# KIRKLEES METROPOLITAN COUNCIL INVESTMENT & REGENERATION SERVICE

Reference No:	<b>2024/65/90270/W</b>
Site Address:	Queensgate Market, Princess Alexandra Walk, HD1 2UJ
Description:	Listed Building Consent for demolition, alteration, refurbishment and extension to create library, food hall and public realm (part within a Conservation Area)
Recommending Officer:	David Wordsworth

## **Application: 2024/90270**

**Proposal:** Listed Building Consent for demolition, alteration, refurbishment and extension to create library, food hall and public realm (part within a Conservation Area).

4 West Elevation
 1 : 200

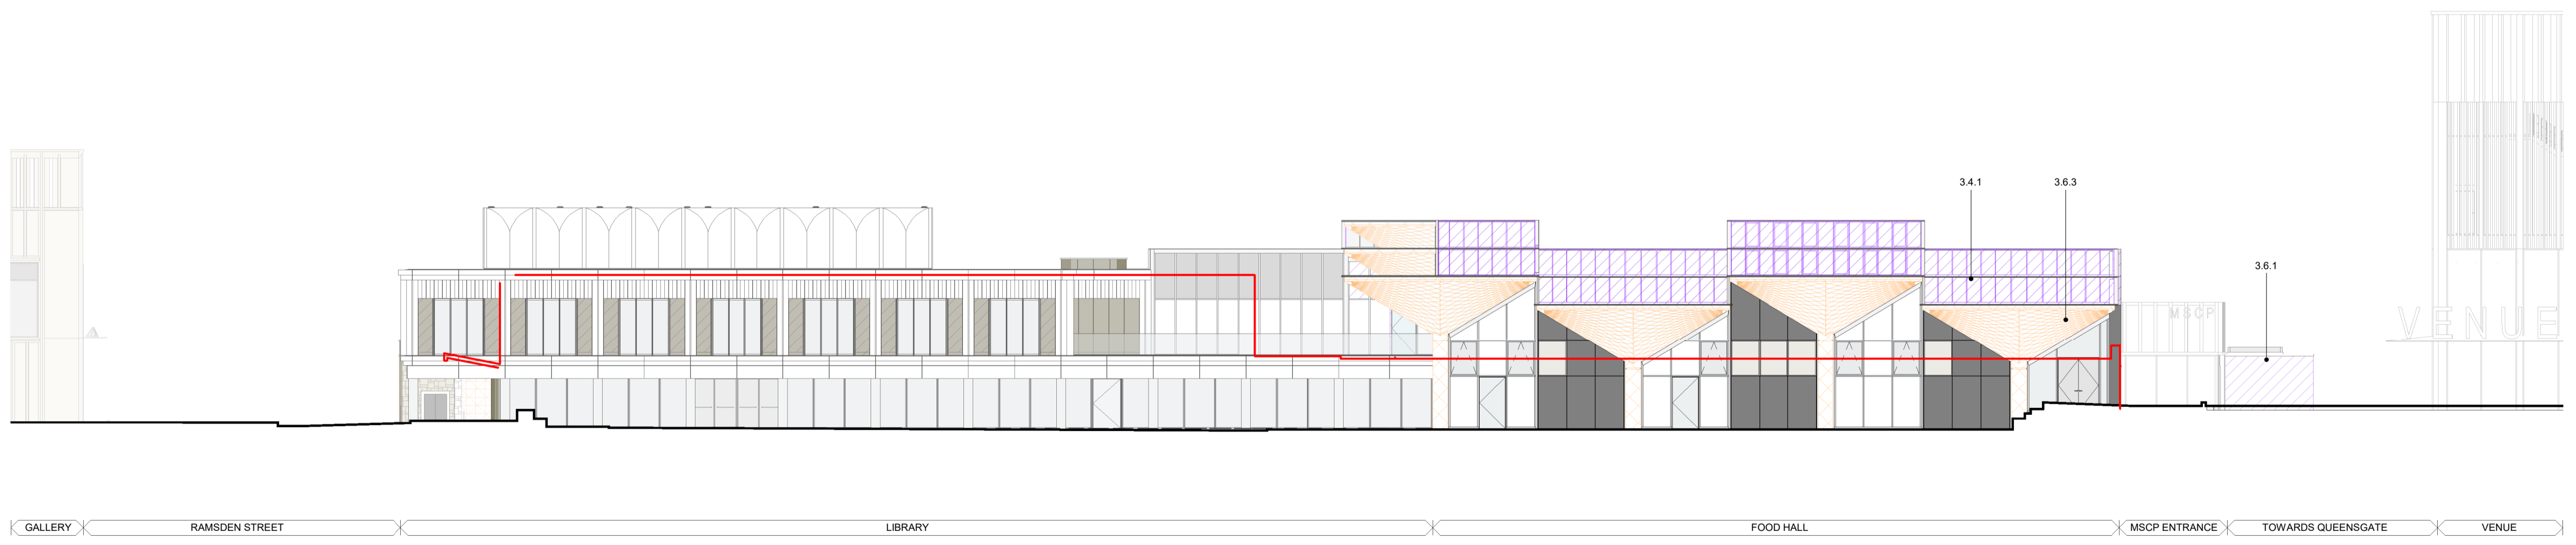
*West elevation:*

A fully glazed west elevation of the food hall was approved and has been amended to a mix of glazing and solid cladding. As this is a new elevation following the approved demolition of the existing west elevation, no historic fabric would be affected by the change. The proposed metal panel cladding replicates the format of the approved glazing modules and would improve the thermal performance of this elevation with no impact on significance, subject to detailing and materials being submitted for approval.

6.2.4 First Floor Plan

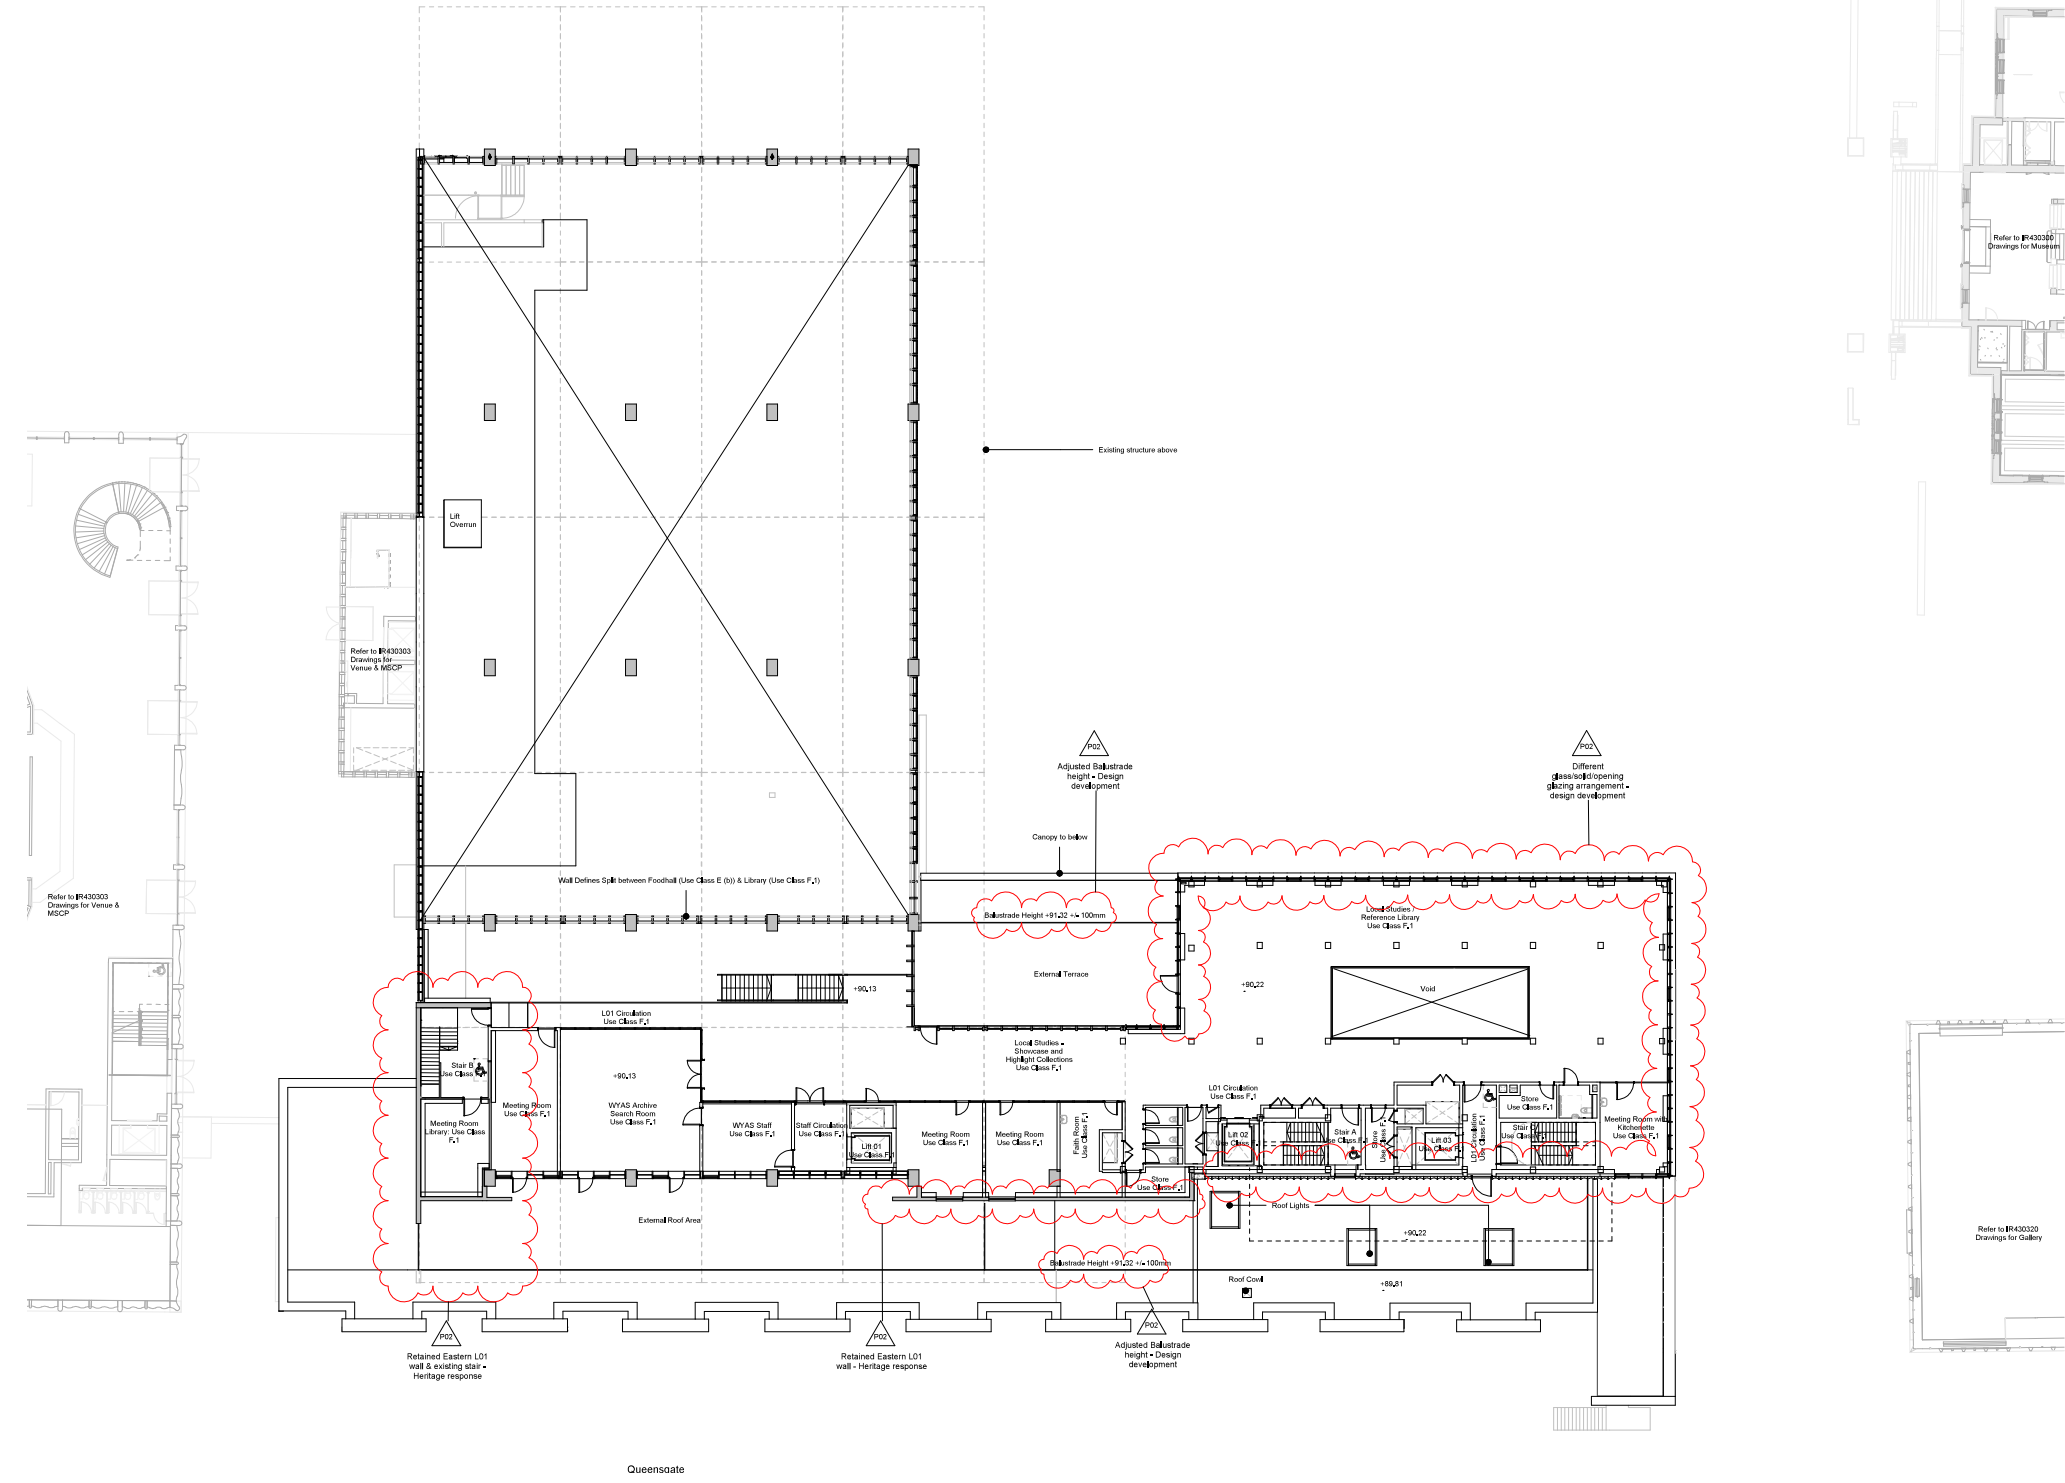
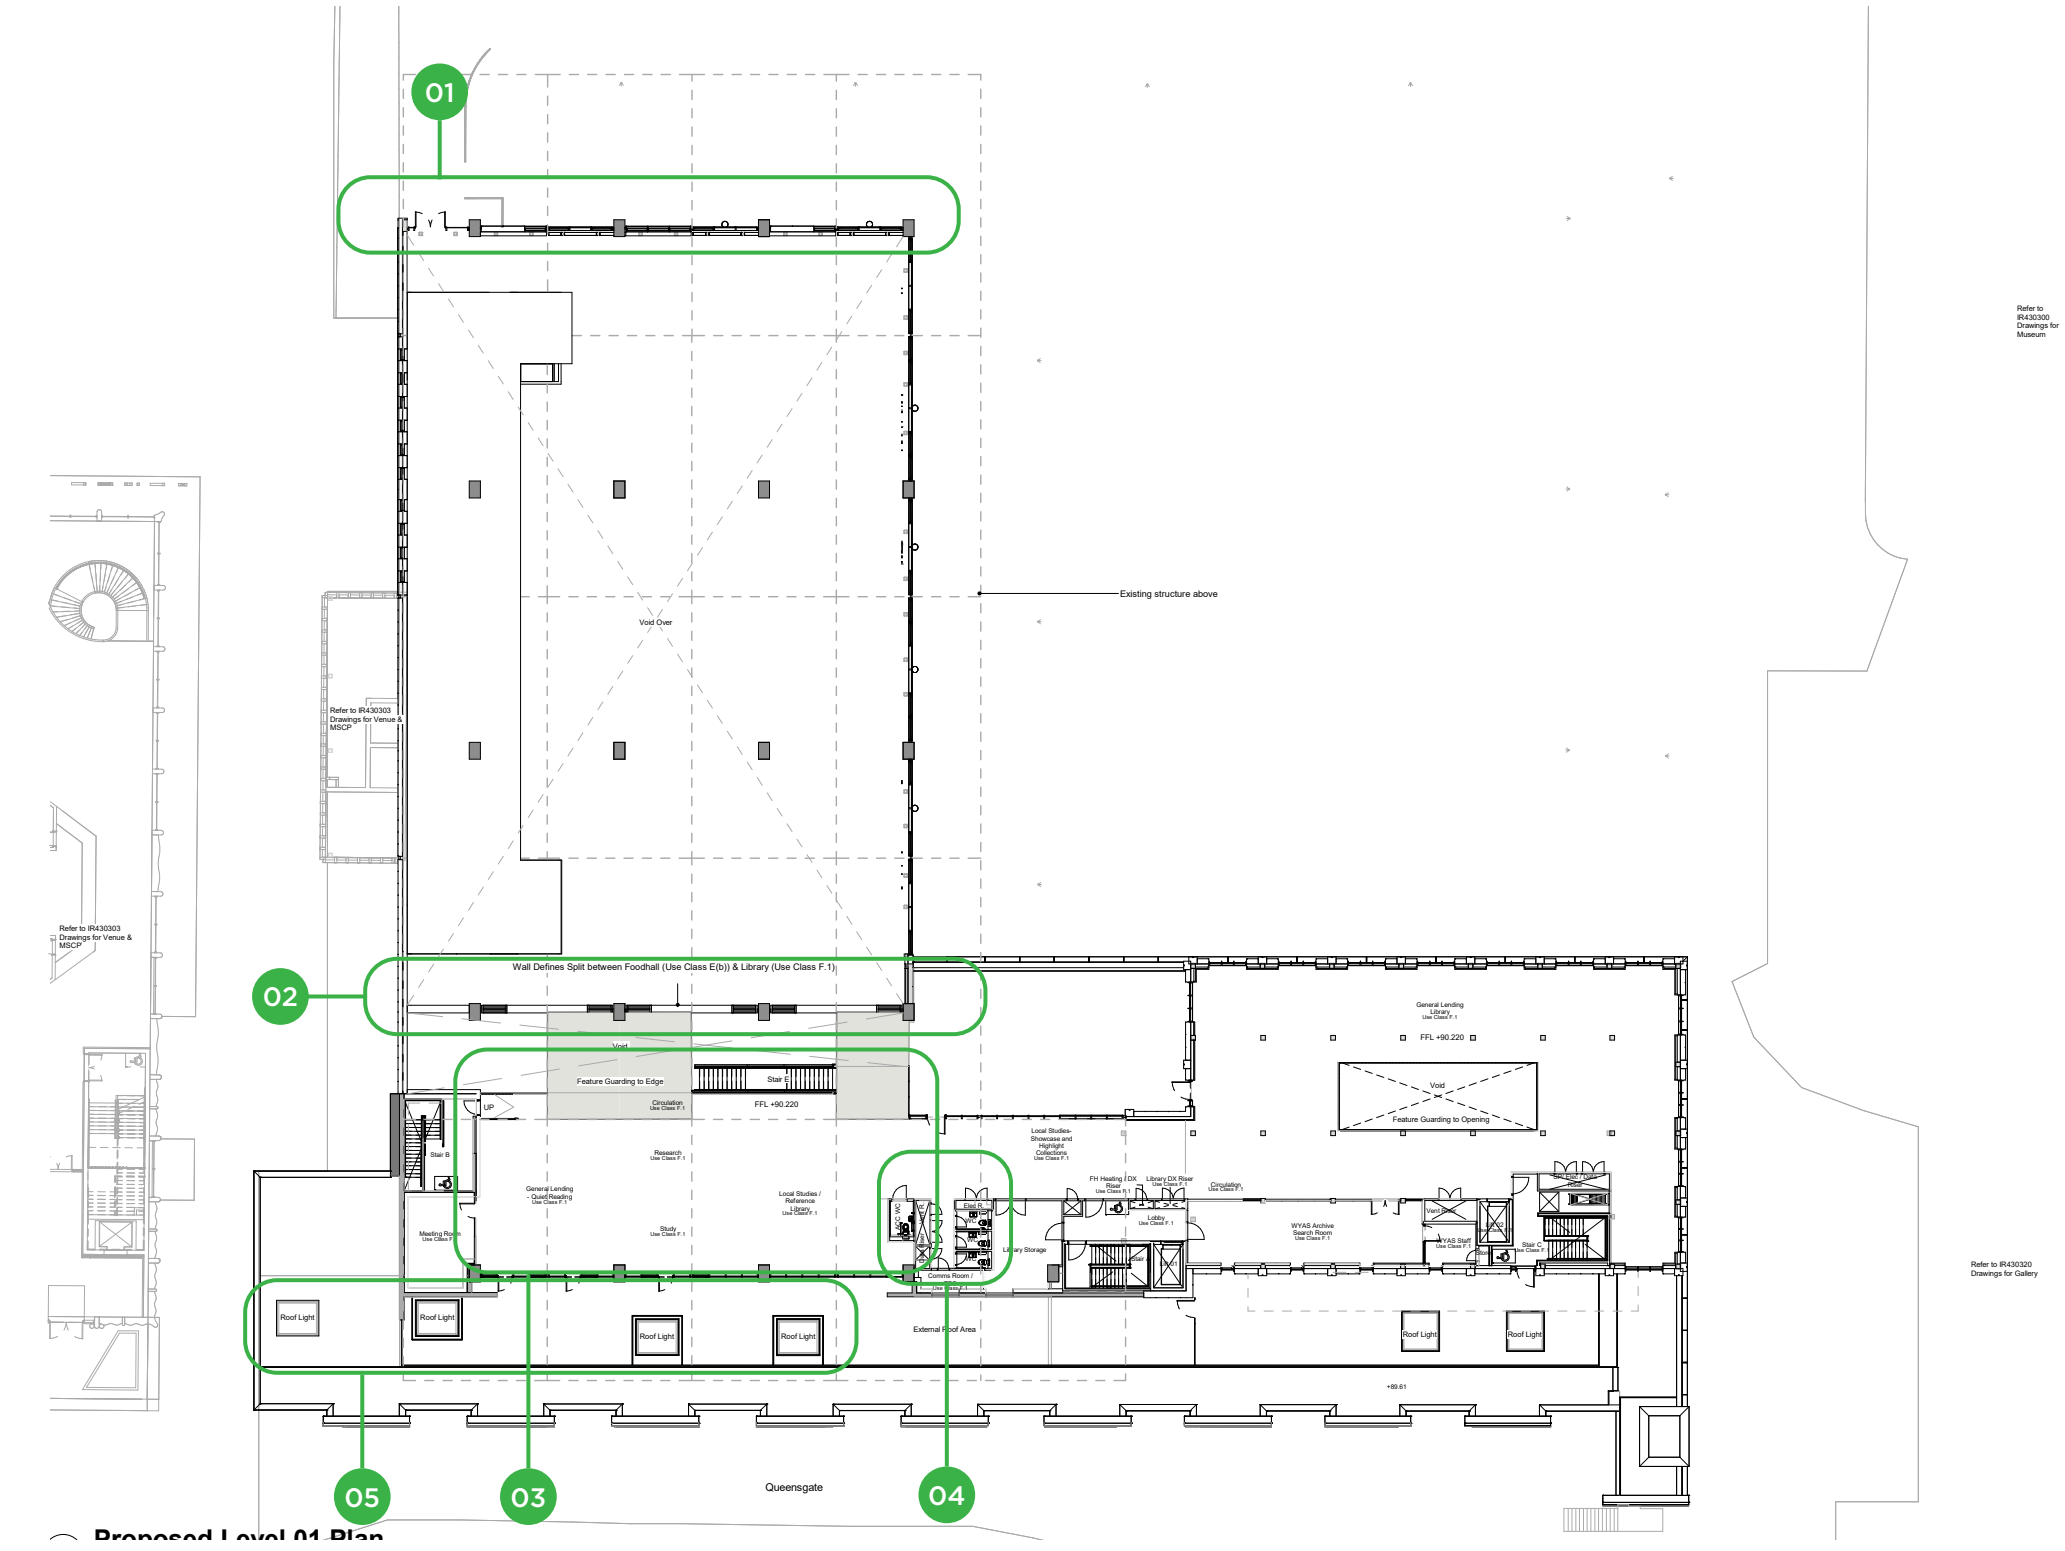
*Internal partition between the food hall and library:*

The amended proposal is for the introduction of a solid fire separation wall with fire rated windows instead of fire rated curtain wall glazing between the library and food hall as approved. The existing first floor partition is fully glazed while the ground floor is open plan in this area. The Conservation and Design Team considers this revision to lead to less than substantial harm to the significance of the listed building by the loss of panoramic views of the interior of the market hall from the first-floor library. The applicant has submitted justification to support this amendment, these being limited suppliers of glazed curtain walling and a lack of fire test certification for these products. Officers are of the view that it is important that the impressive views of the parabolic mushrooms across the market hall are maintained. The new partition limits the view from the first floor, but a partial view would be maintained to some extent by installing a pair of vertical windows within the new wall to the side of each column, with their proportions designed to enhance the vertical emphasis of the columns. Officers are disappointed that a solid partition is necessary but understand the need to comply with fire regulations and ensure a safe environment.

*First floor library partitions:*

Partitions were previously approved within the first-floor library and these have now been omitted. This would enhance the space and allow an appreciation of the parabolic mushrooms and impressive architecture.
